CITY OF ALBUQUERQUE

**Re: Lowes Pad Site, 6240 Paseo Del Norte NE,
Request for Permanent C.O. - Approved
Engineer's Stamp dated: 07-11-12 (D-18/D014D)
Certification dated: 1-31-13**

Shahab Biazar, P.E.
Senior Engineer, Planning Dept.
Development and Building Services

From: Olson, Greg R.
Sent: Friday, June 29, 2012 1:31 PM
To: 'David Soule'
Cc: Olson, Greg R.; Salgado-Fernandez, Nilo E.
Subject: D18/D014D : Out parcels at Lowes on SW corner of Paseo del Norte & San Pedro David,

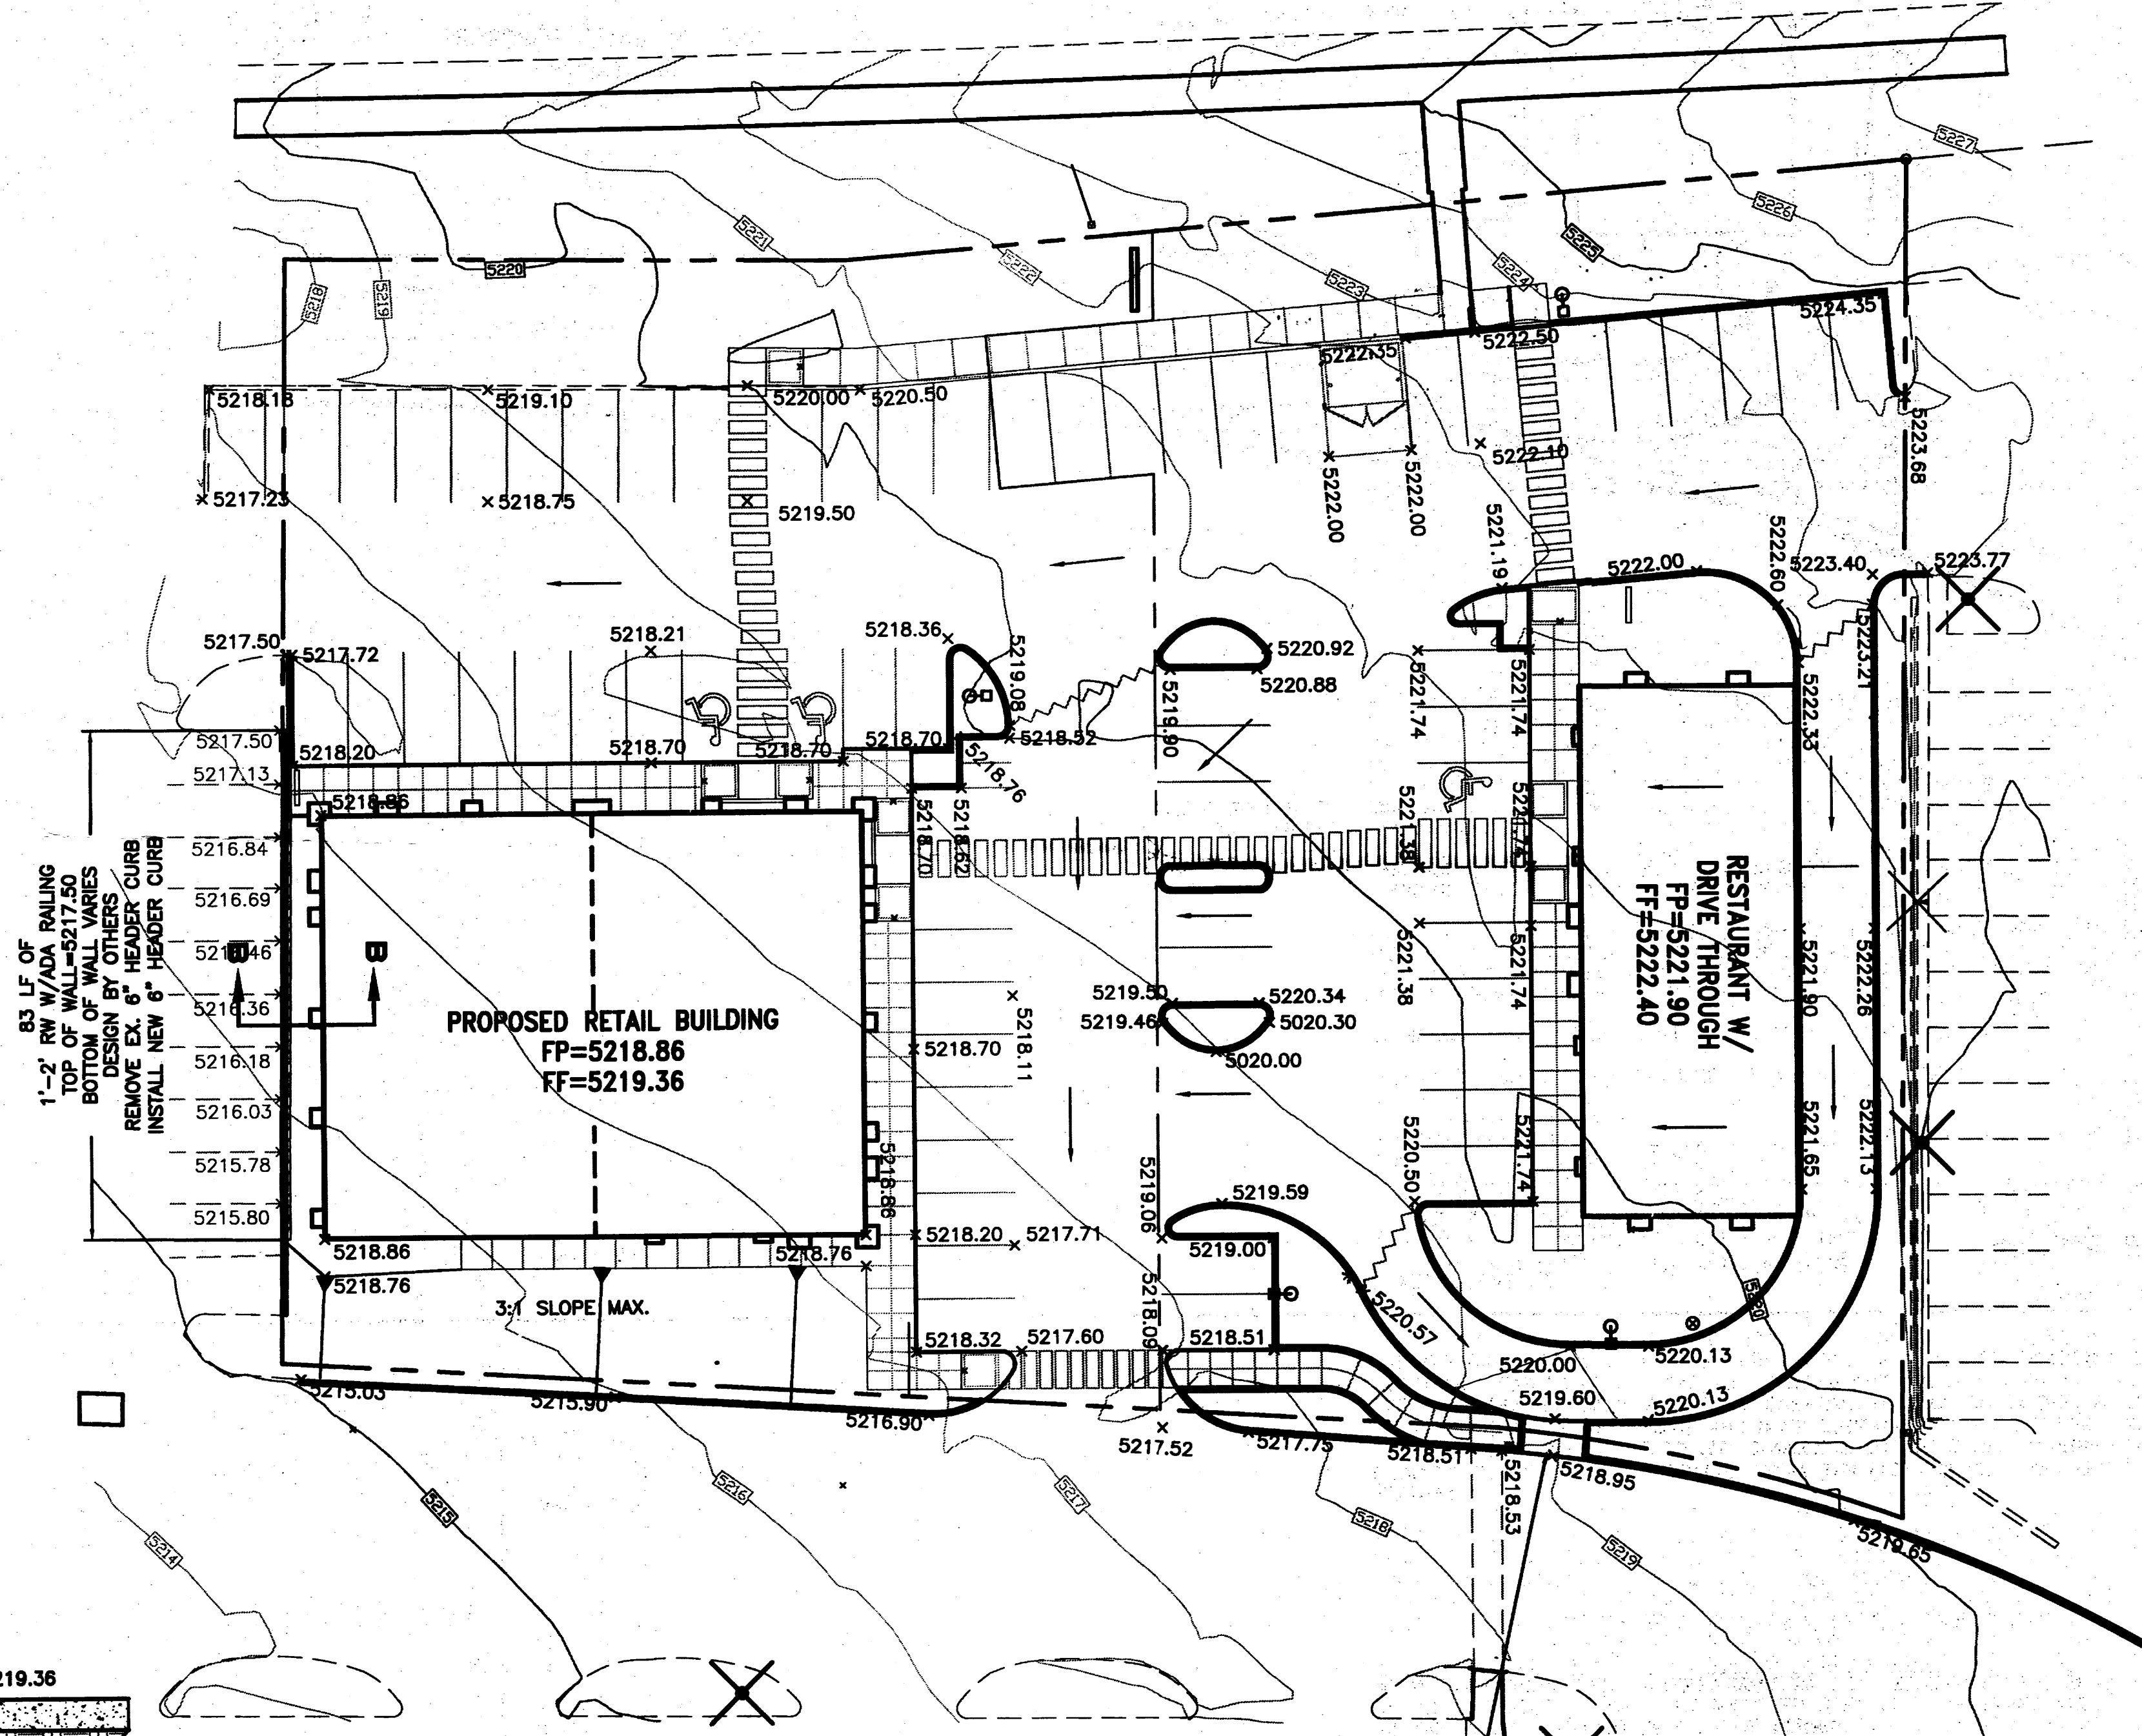
1. **Where does roof runoff go from SW building?** Avoid erosion on the steep side slopes S & W of pad.

2. Per DPM, the Dumpster pad for the restaurant must drain to the Sanitary Sewer.
Show this on the plan.

3. At the 10' rundown south of the restaurant:

- a. at 10' wide will it become a shortcut to the drive-through?
- b. The original Lowes site had a N-S pedestrian corridor just west of the restaurant pad.
 This plan seems to carry that through the site, except at the drive-through.
 Will it be continuous, and will it be **compatible with the drainage rundown?**
